Case Officer: Bob Neville

Recommendation: Refusal

Applicant: Mr R Bratt

Proposal: Erection of garage adjacent to approved dwelling and change of use of agricultural land to residential use

DRAWING:
Proposed Elevations (Sheet 2 of 2)

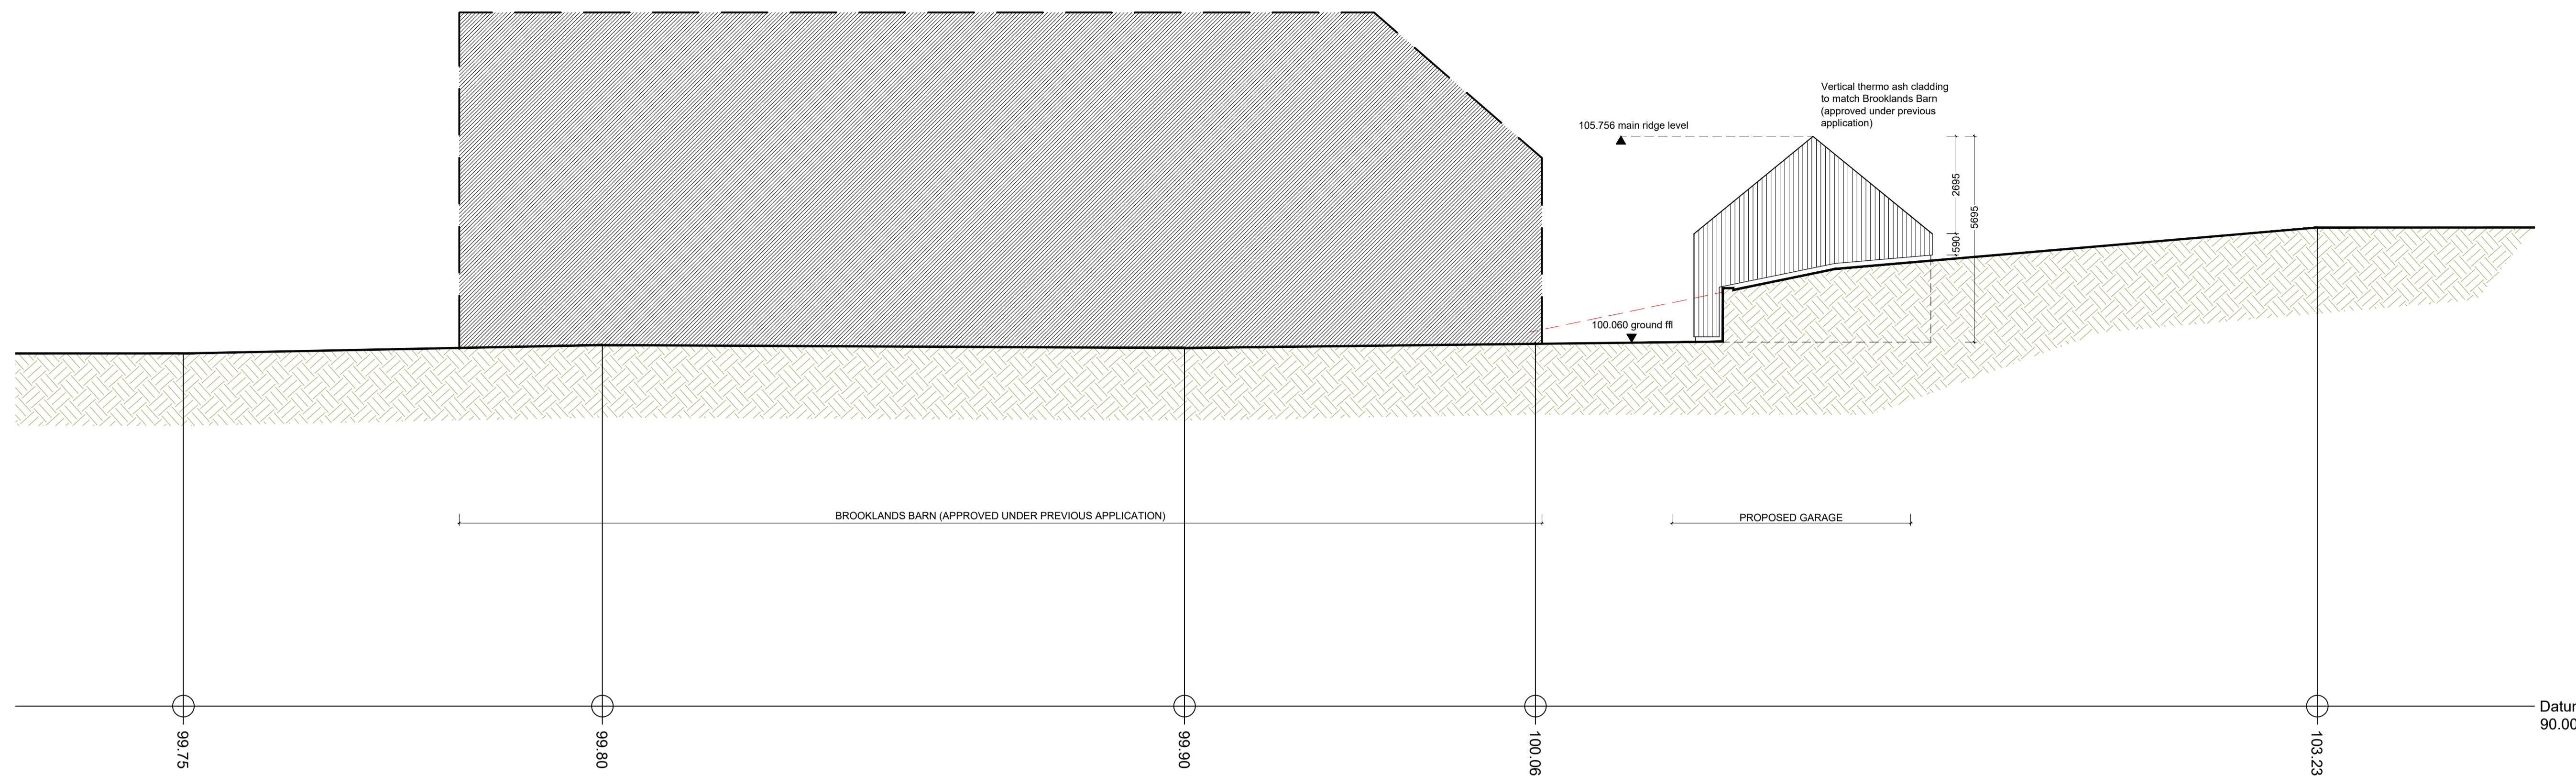
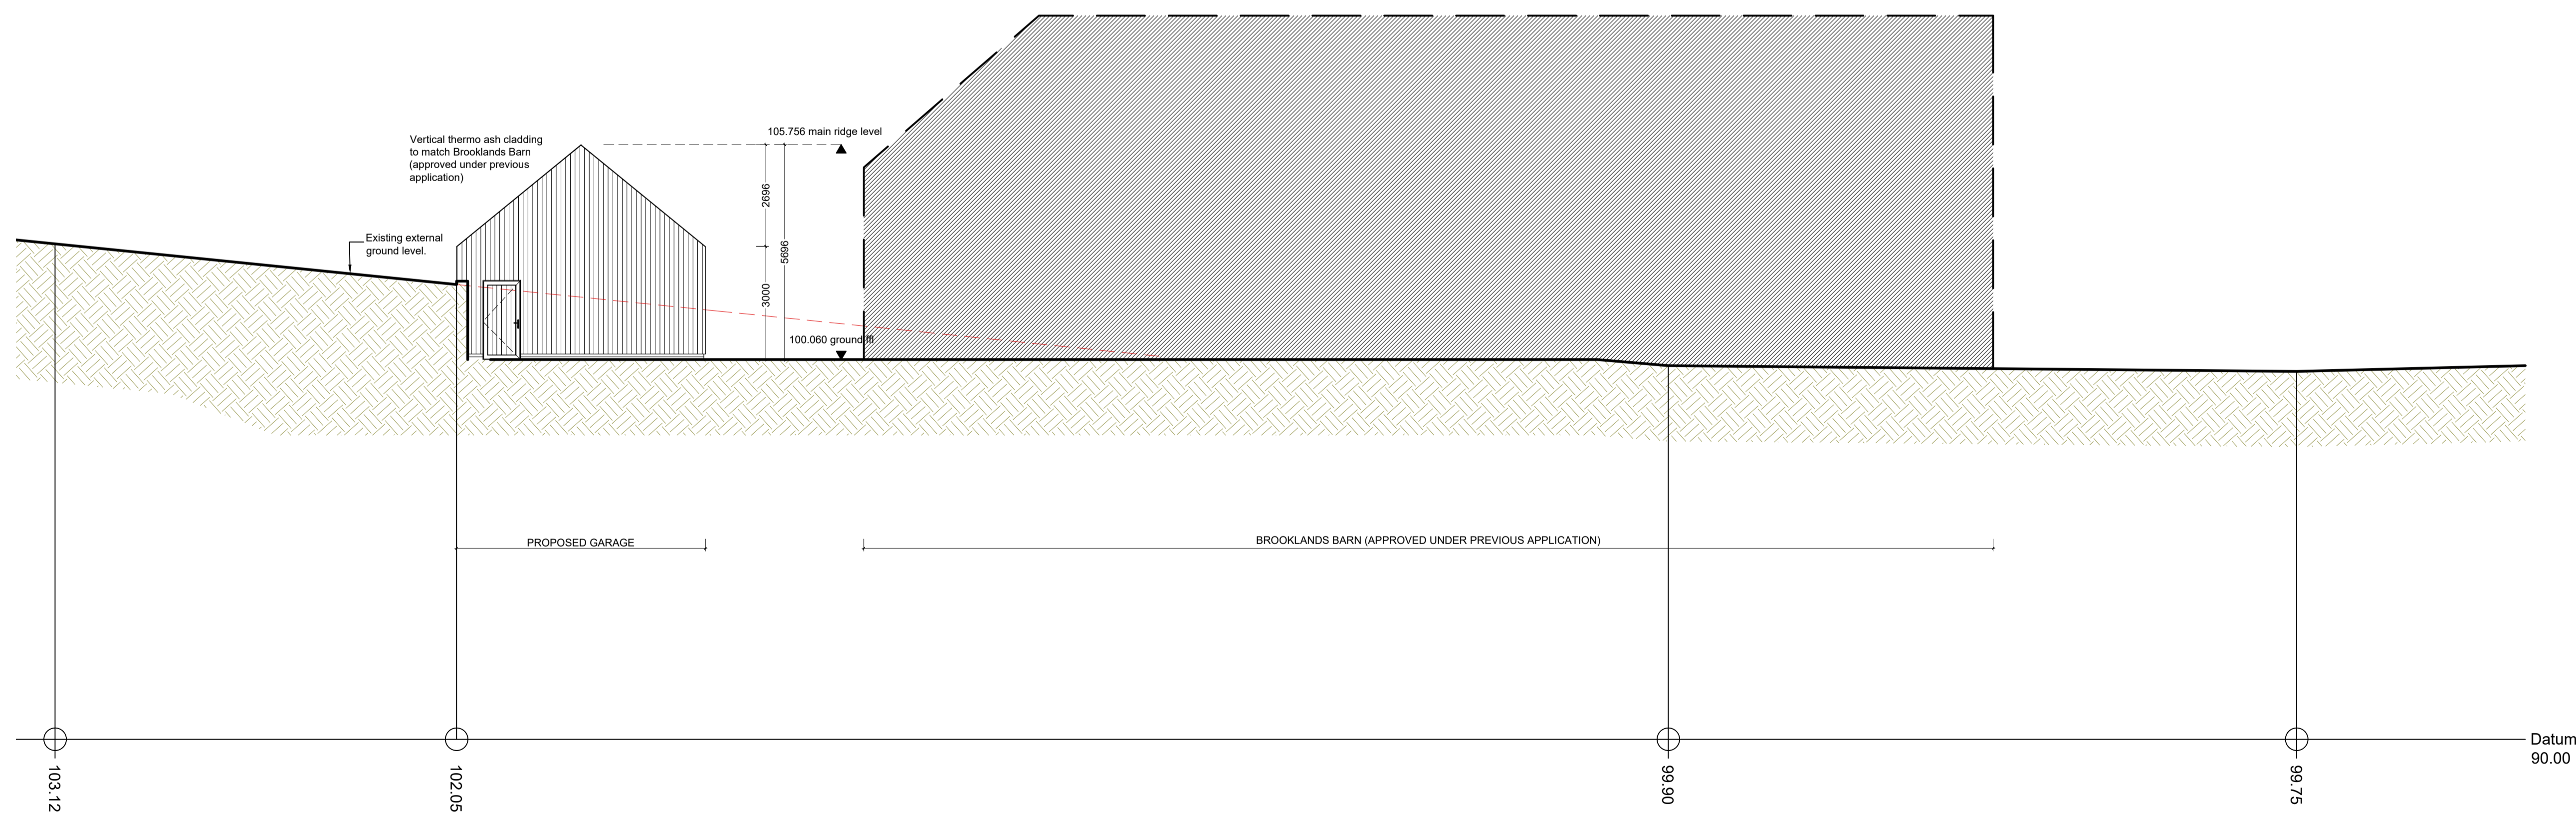
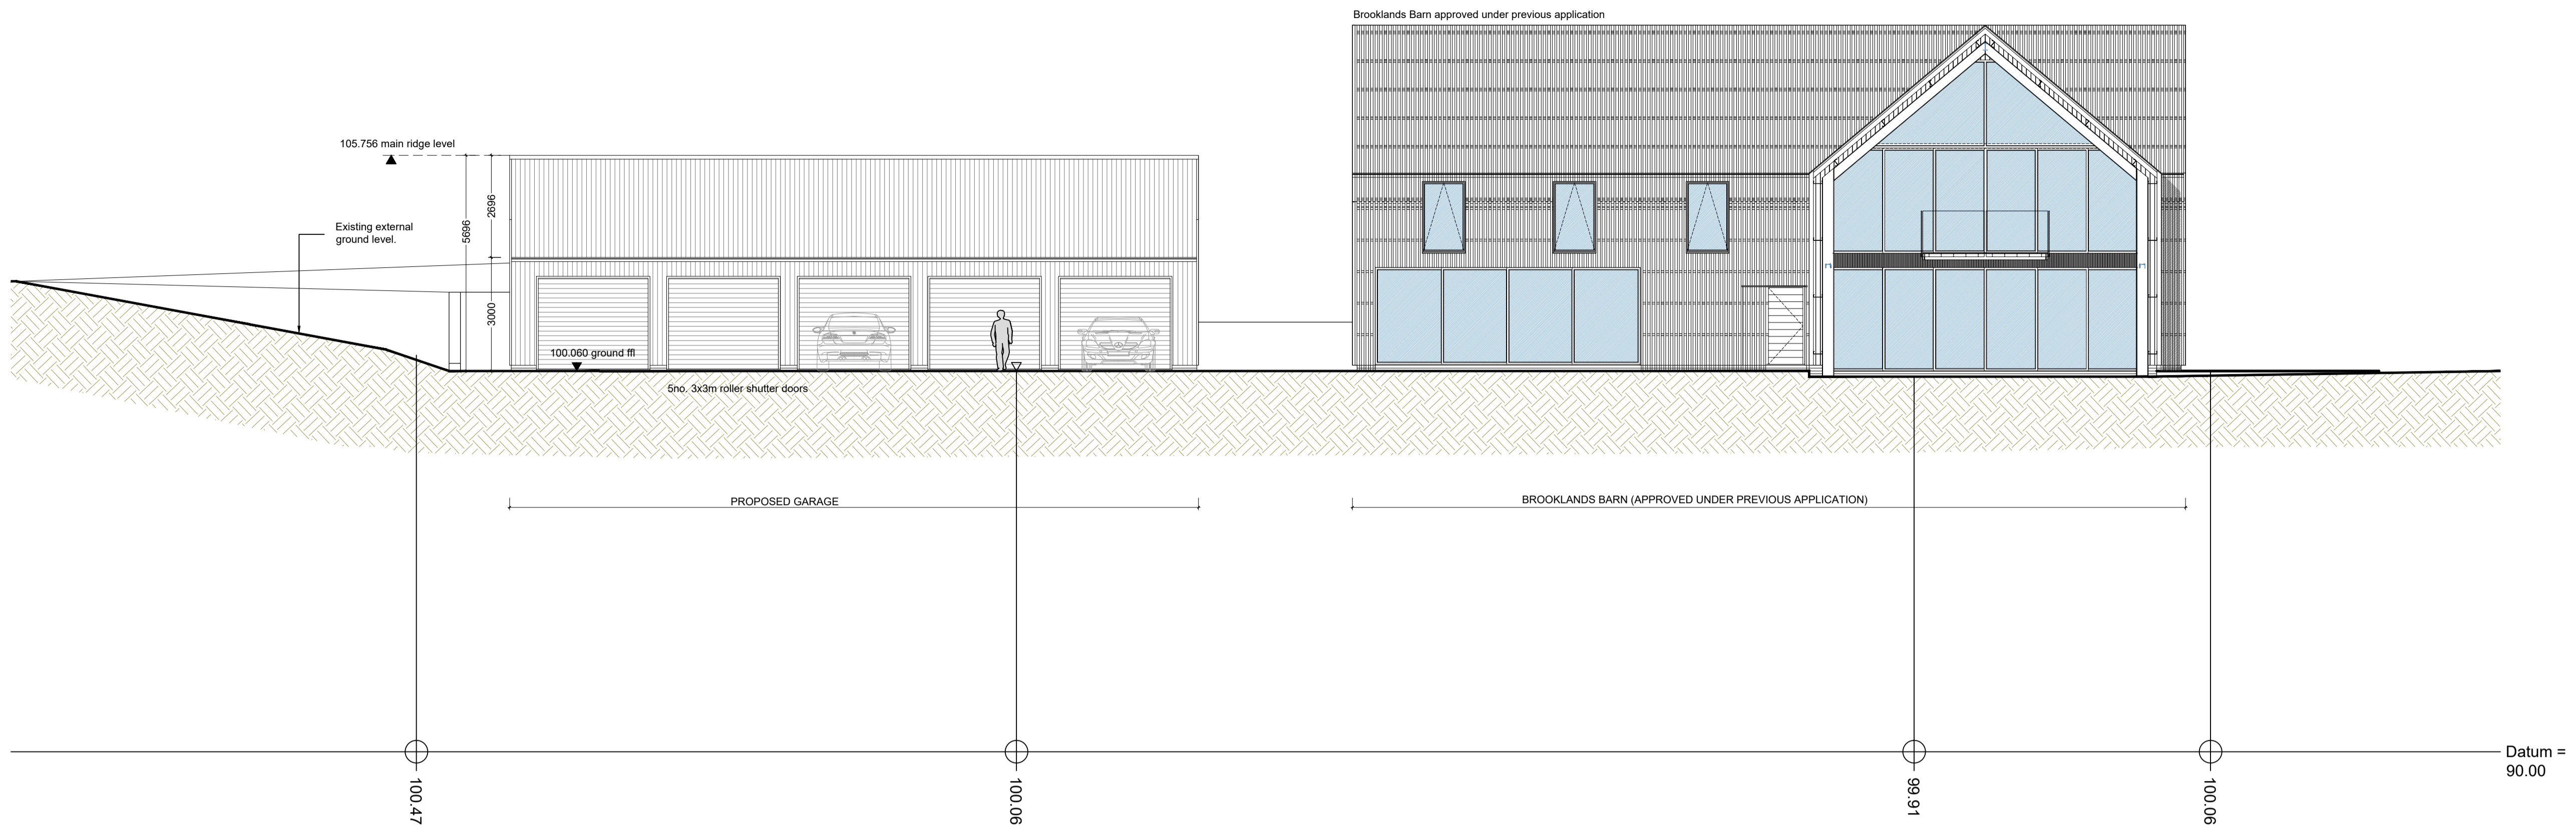
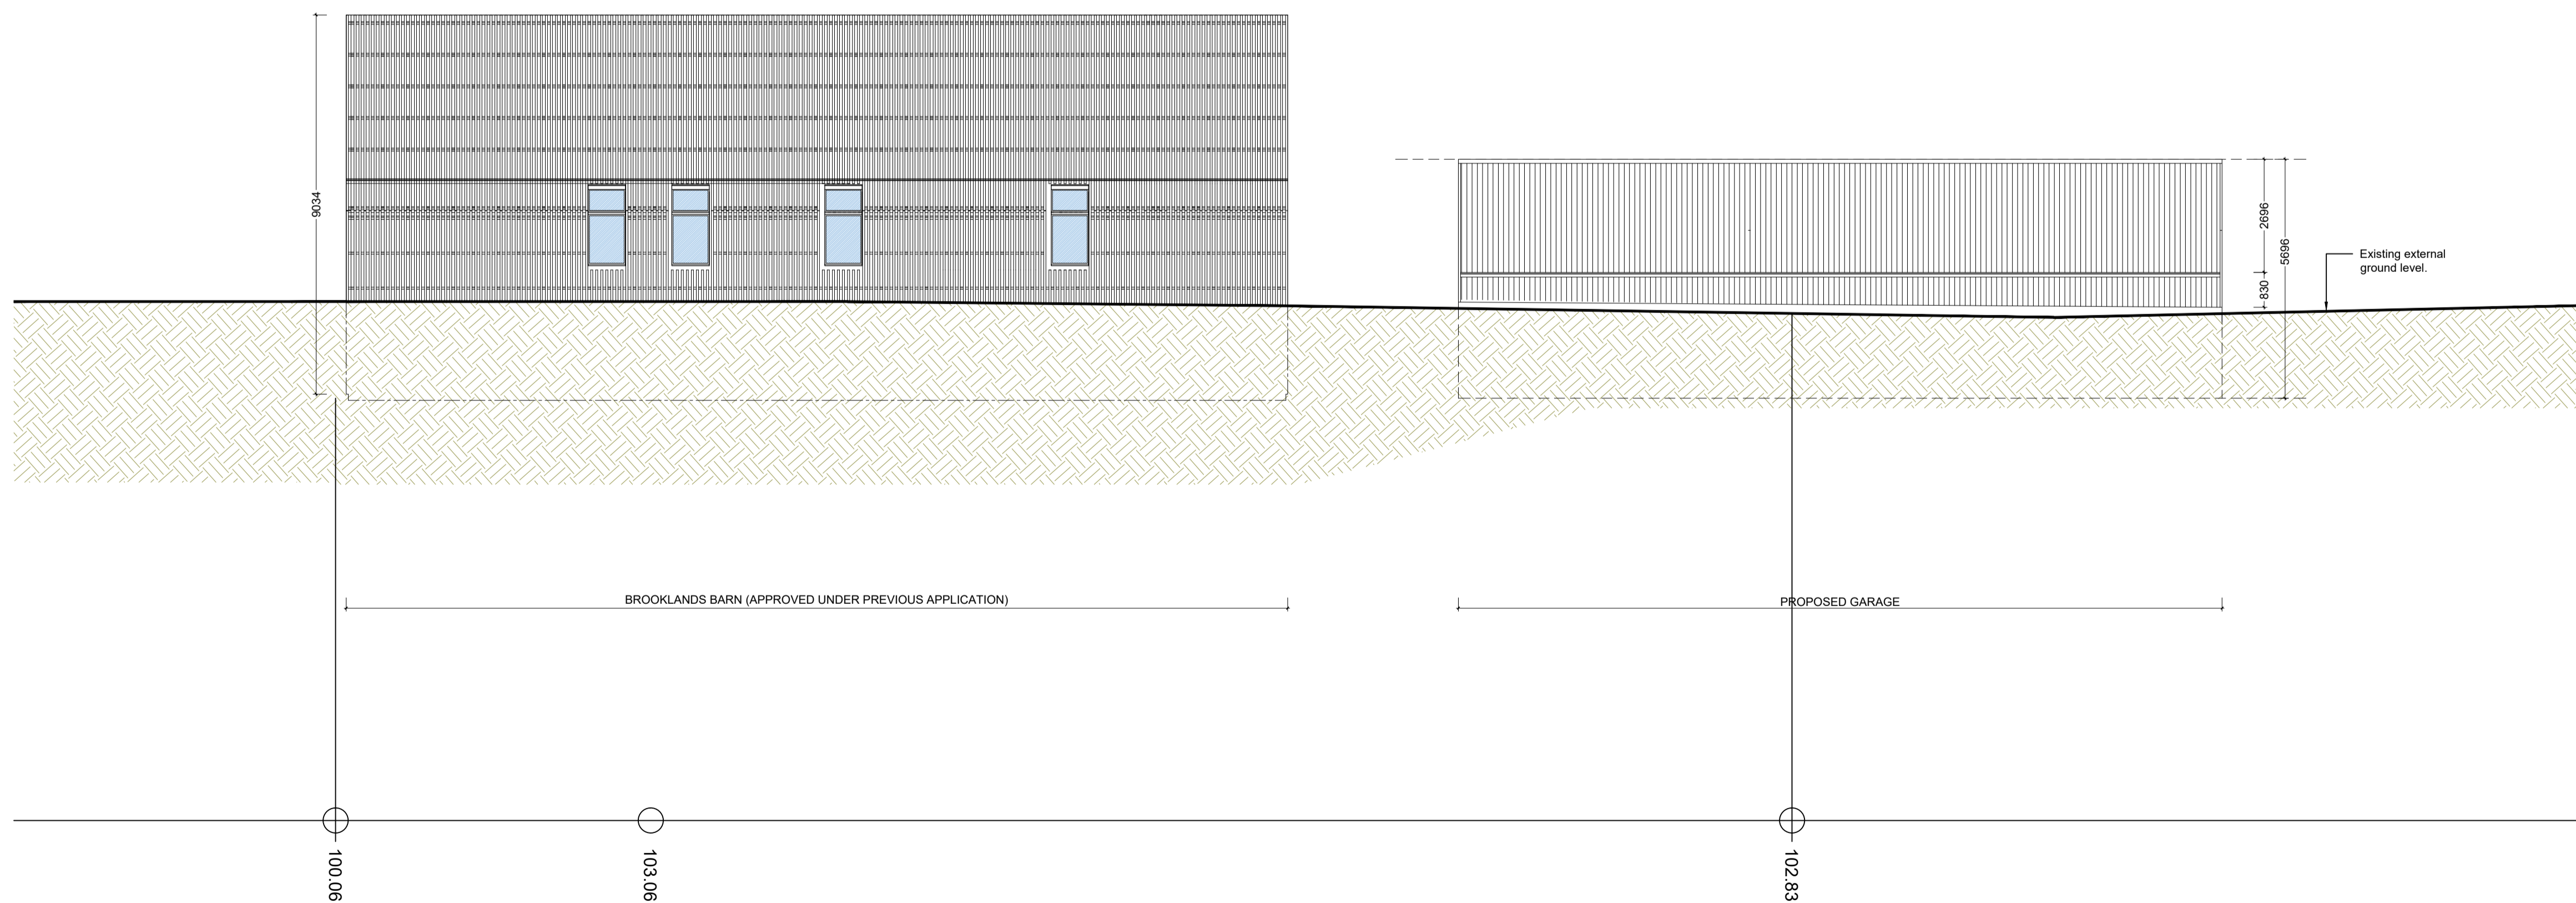
- 8.6. As noted above the proposed garage building is *substantially* larger than what might be considered a typical domestic garage. The proposed building would be sited to the north-west of the on-going development at the site and would be poorly related to and appear somewhat divorced from the main dwelling. Whilst materials are proposed to match those proposed on the main dwelling, the overall appearance of the building would appear somewhat more commercial than a residential garage, largely due to the number of bays proposed.

- 8.10. The landscape officer (who has assessed the applicant's LVA) echoes the concerns of the case officer, advising that the proposal has potential for localised visual harm to visual receptors using the Church Street/Public byway 136/20-137/12, looking over the field gate (near Viewpoint 1 of the LVA), with further distance views also experienced from points along the PRoWs (which cross land south of the site at an elevated position and also east of the site. It is considered that the current proposed location of the garage outside the geometric alignment of the barn conversion means that it is quite visually prominent from these locations.
